**WEST SUSSEX COUNTY COUNCIL
STRATEGIC PLANNING CONSULTATION**

DATE: 19th May 2015

SUBJECT: LU/114/15/RES - Approval of reserved matters following outline permission LU/47/11 for layout, appearance and landscaping of access road.

LOCATION: Land north of Toddington Lane, east of southern section of proposed by-pass and west of parcels B3 and B5, Littlehampton BN17 7PP.

Drawing No. CV8140927/601-1

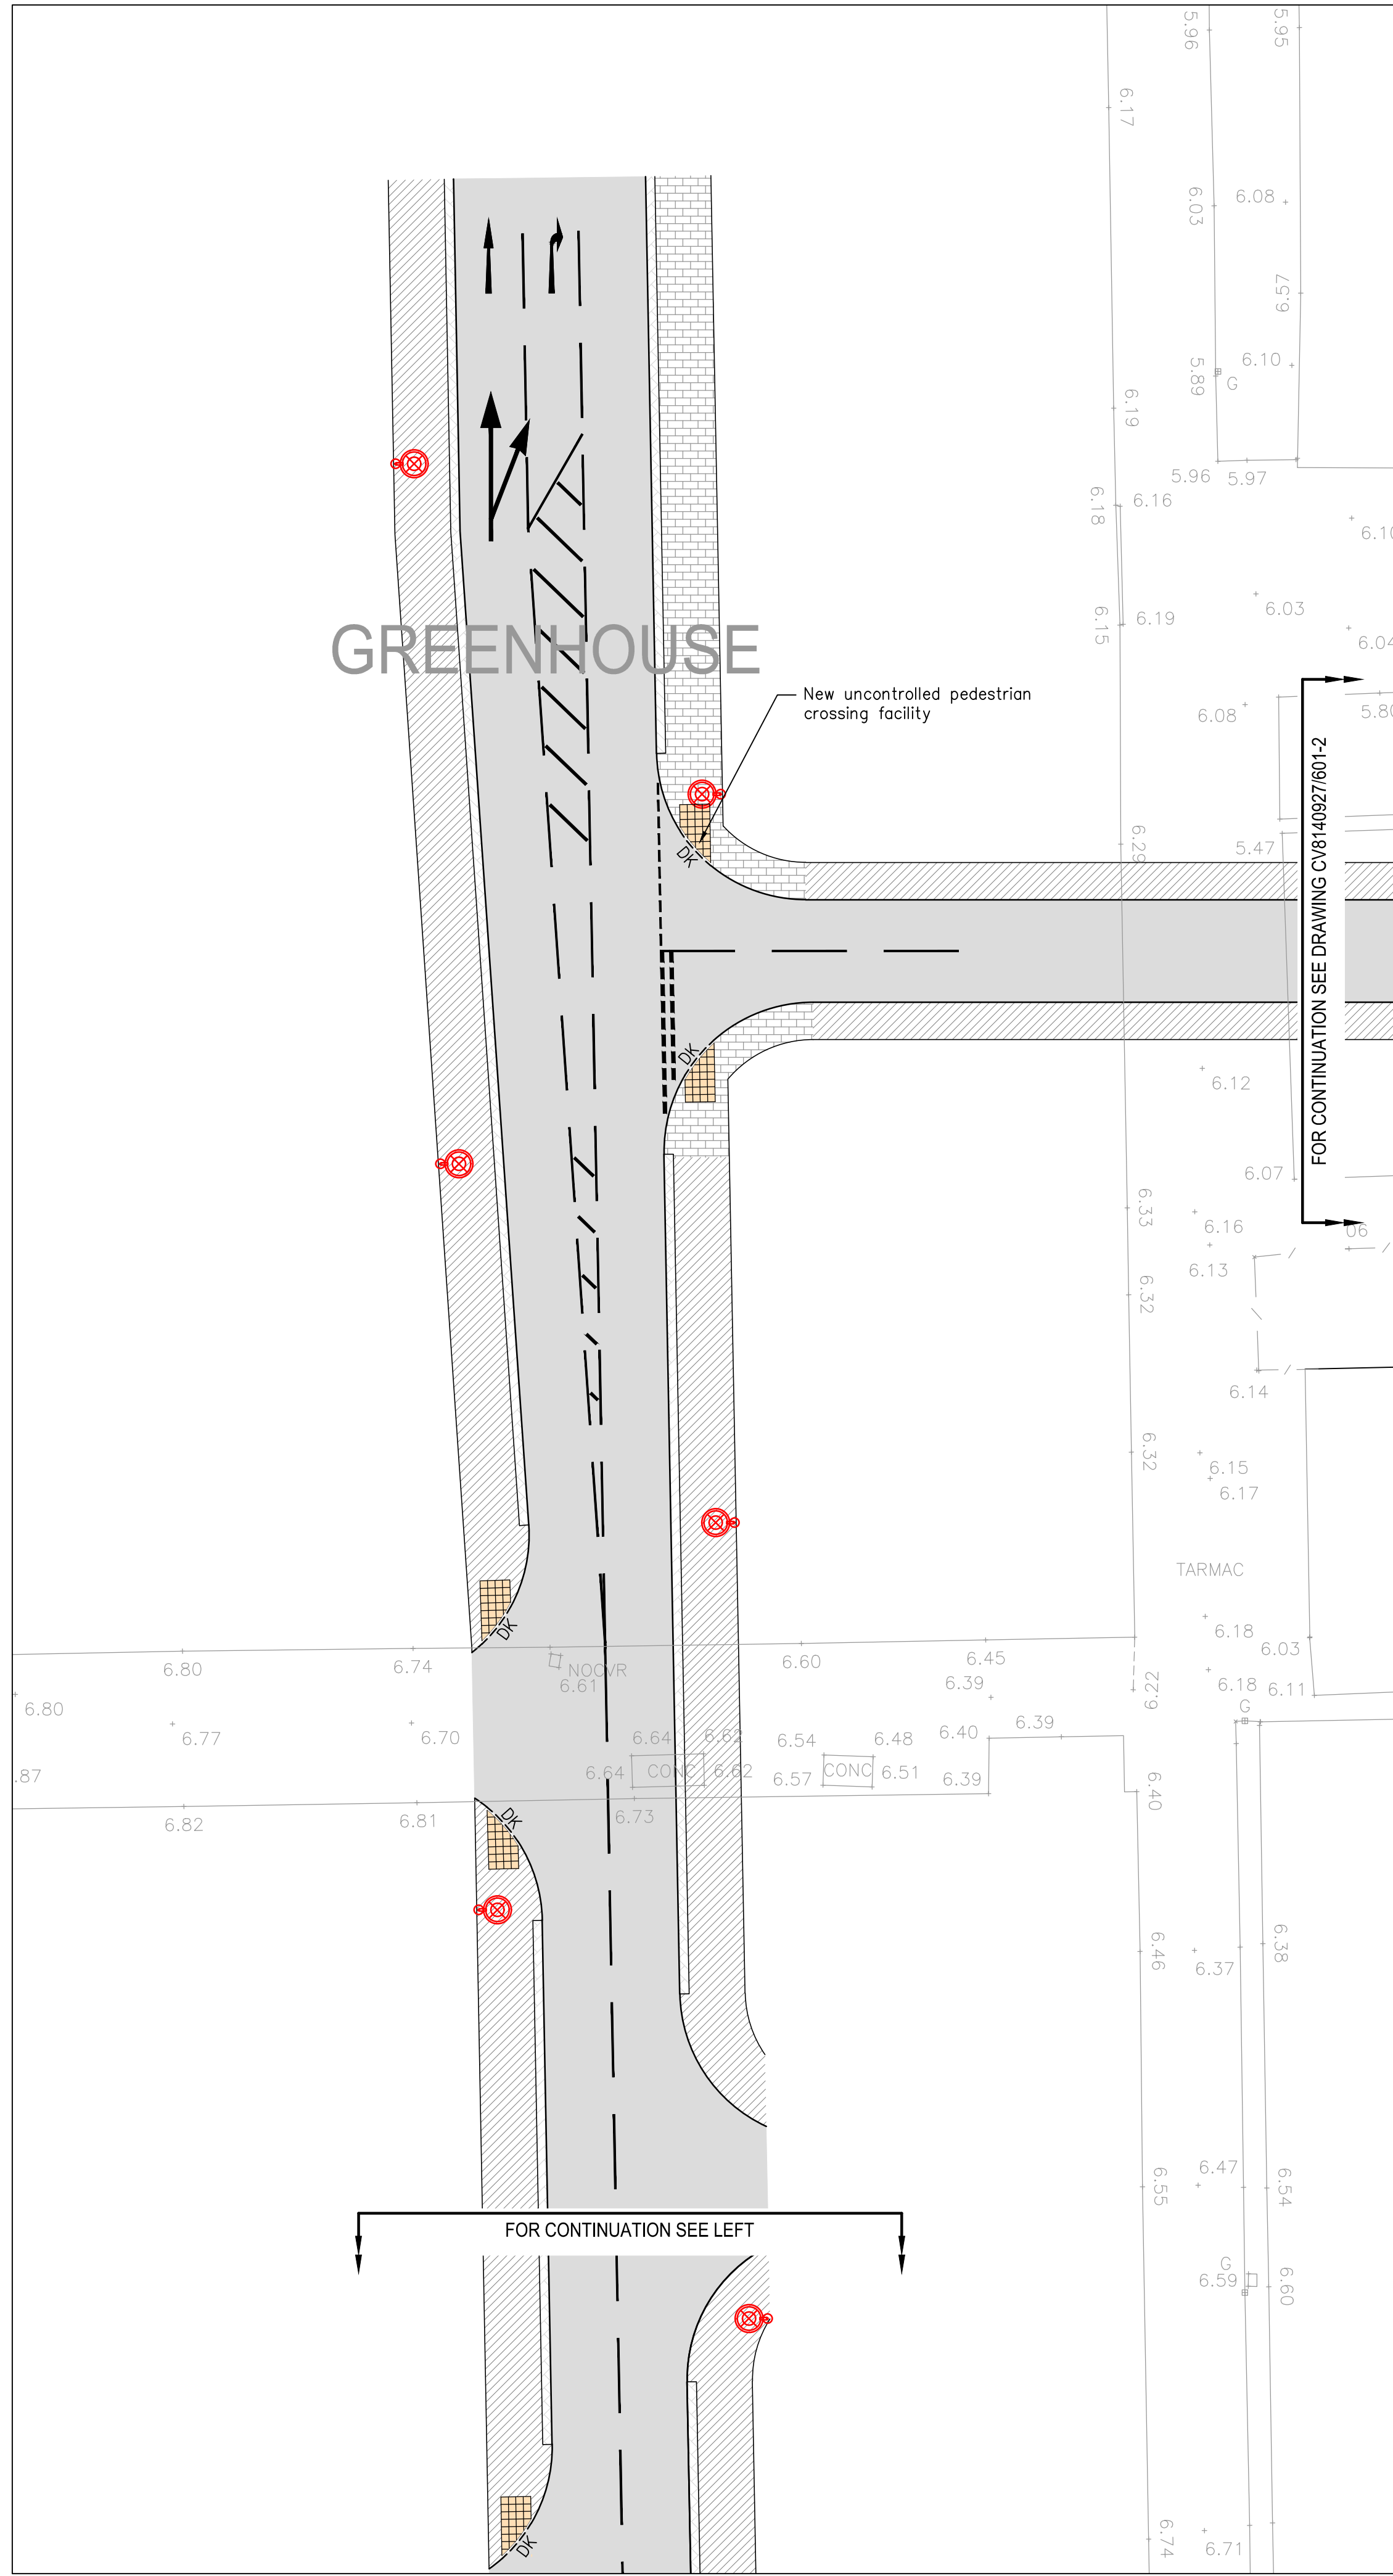
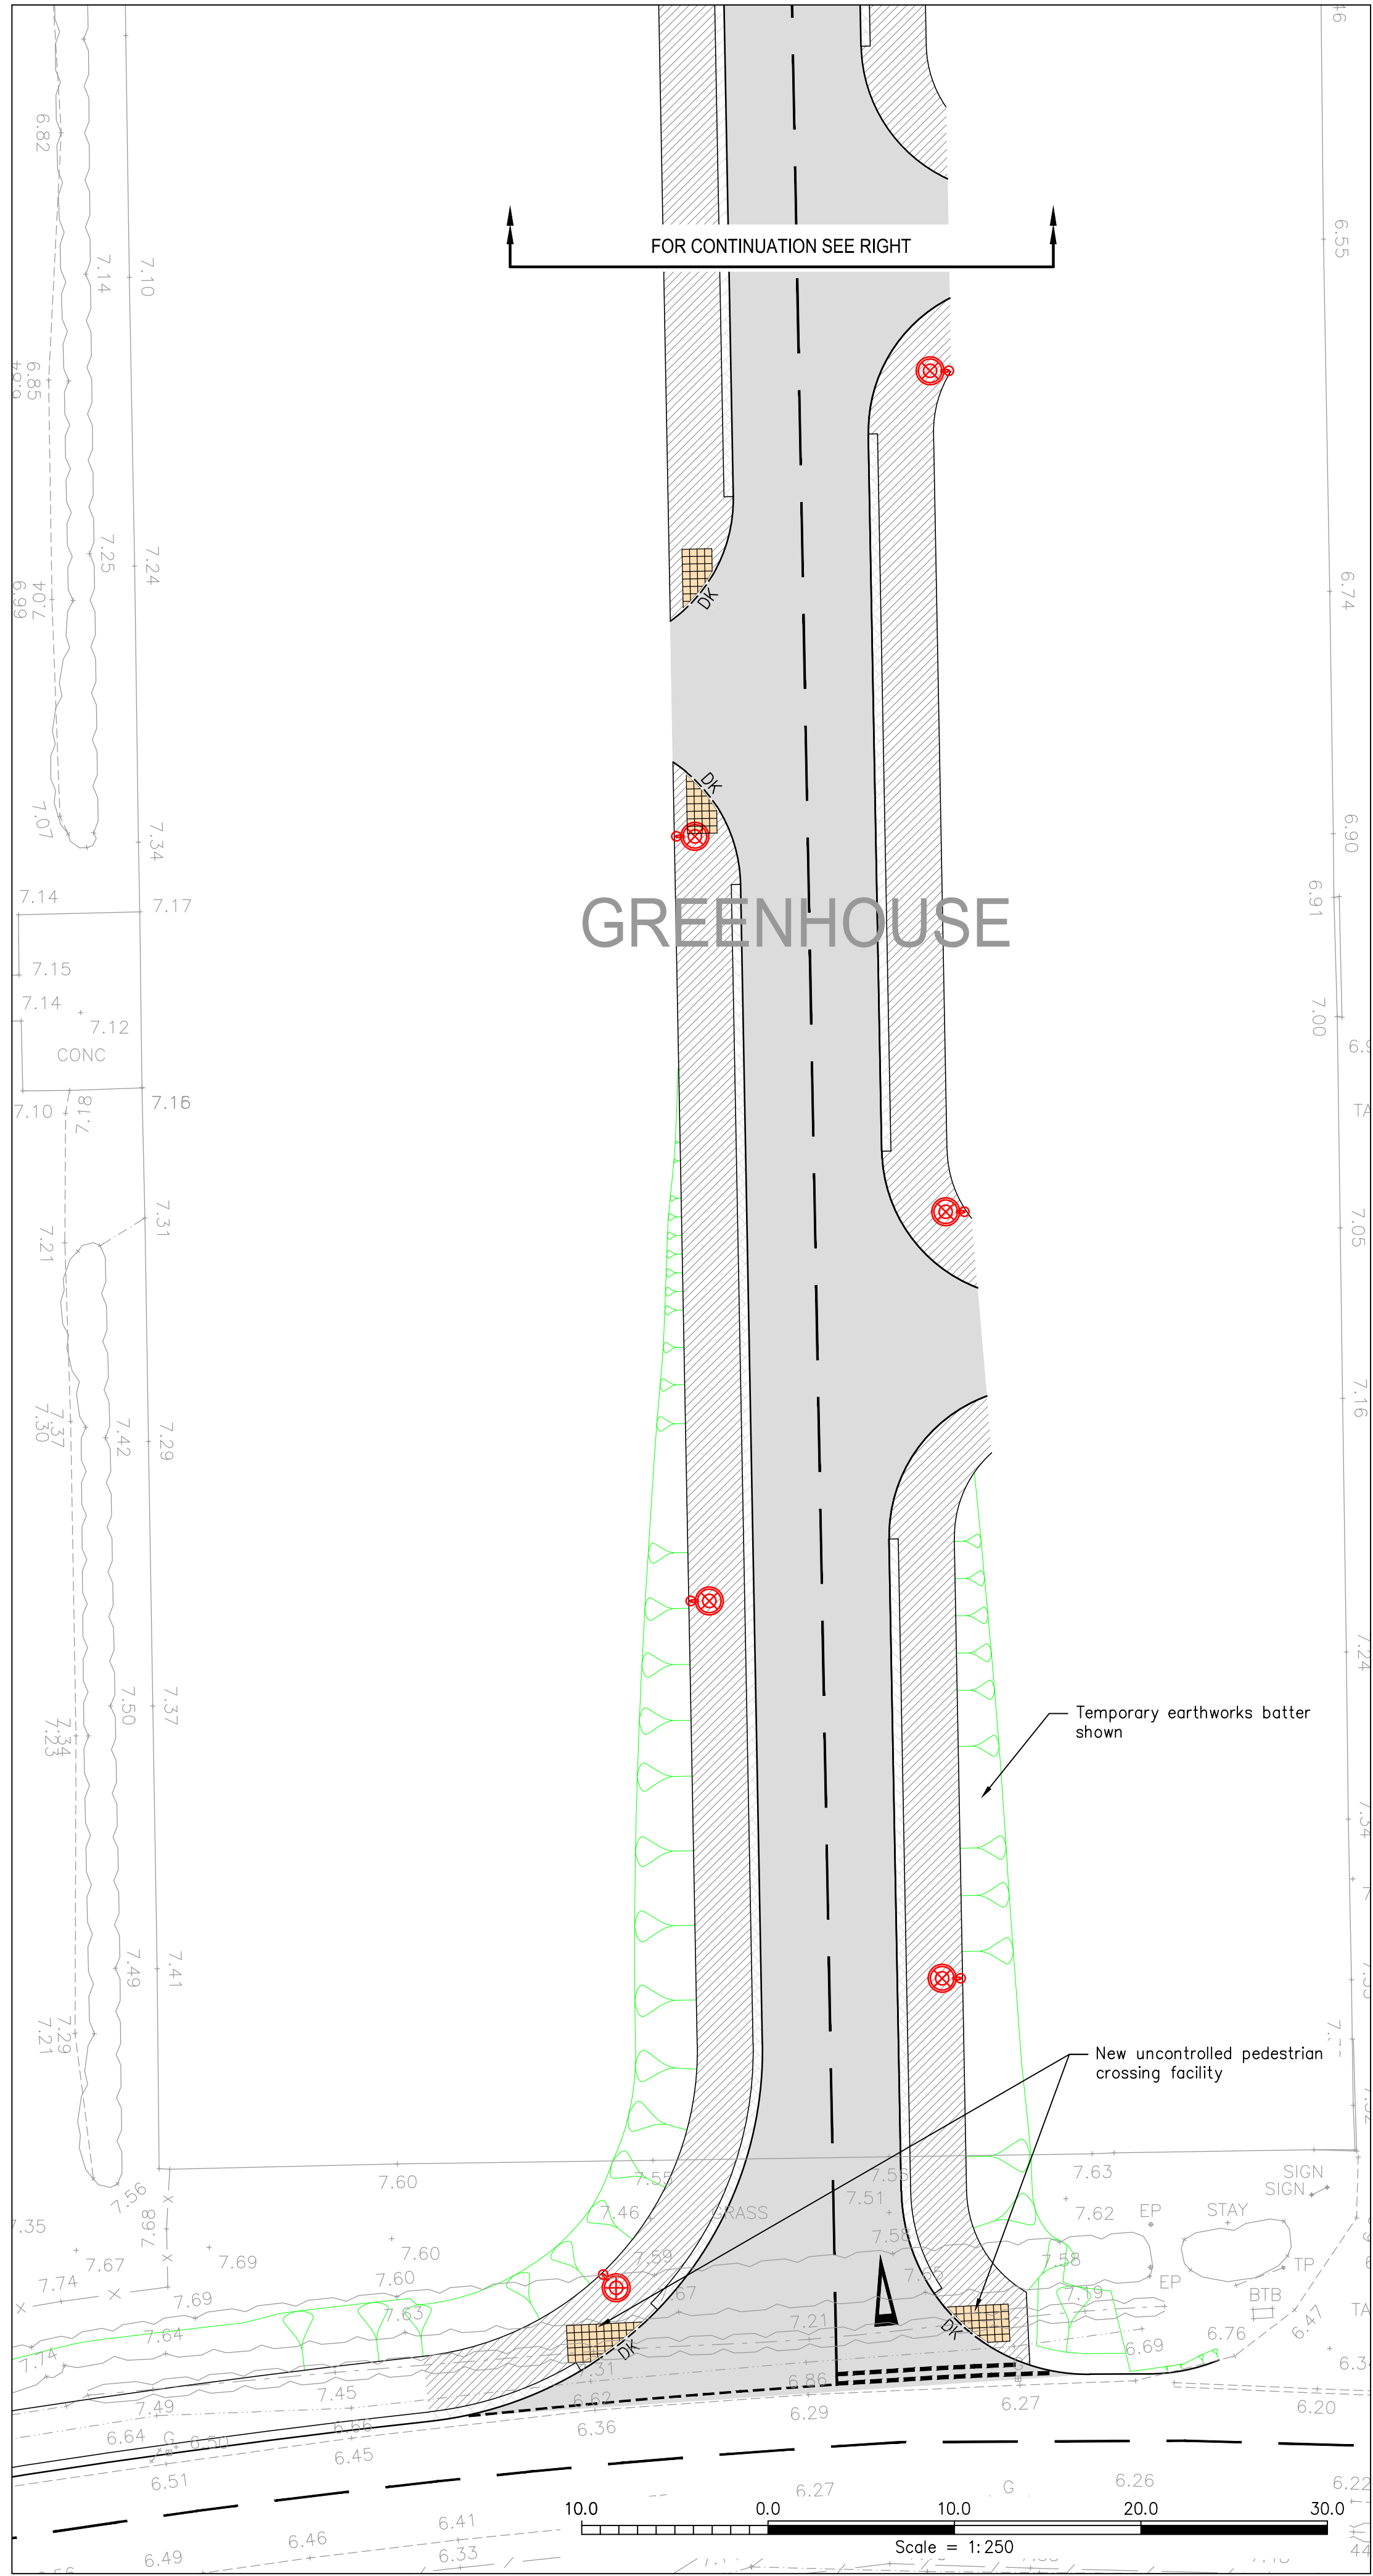
6. Block paved cycle routes are not acceptable to Highway Authority for reasons of construction, maintenance and ease of use. These areas to be (machine) laid in flexible material (and confirmed as such by applicant).

7. Treatment of 'buffer zone' (between road and cycle path) to be considered further at S38 stage. Again, for reasons of construction, maintenance and ease of use, blockwork may not be suitable.

8. Tactile paving (corduroy or similar) to define start and finish of shared footways/cycleways will be considered in detail at S38 stage.
9. For 'crossroad' arrangements on east-west access road, these should be constructed as raised tables in accordance with WSCC standard details. As shown, the rumble strip details are unlikely to provide adequate speed control. Please show.
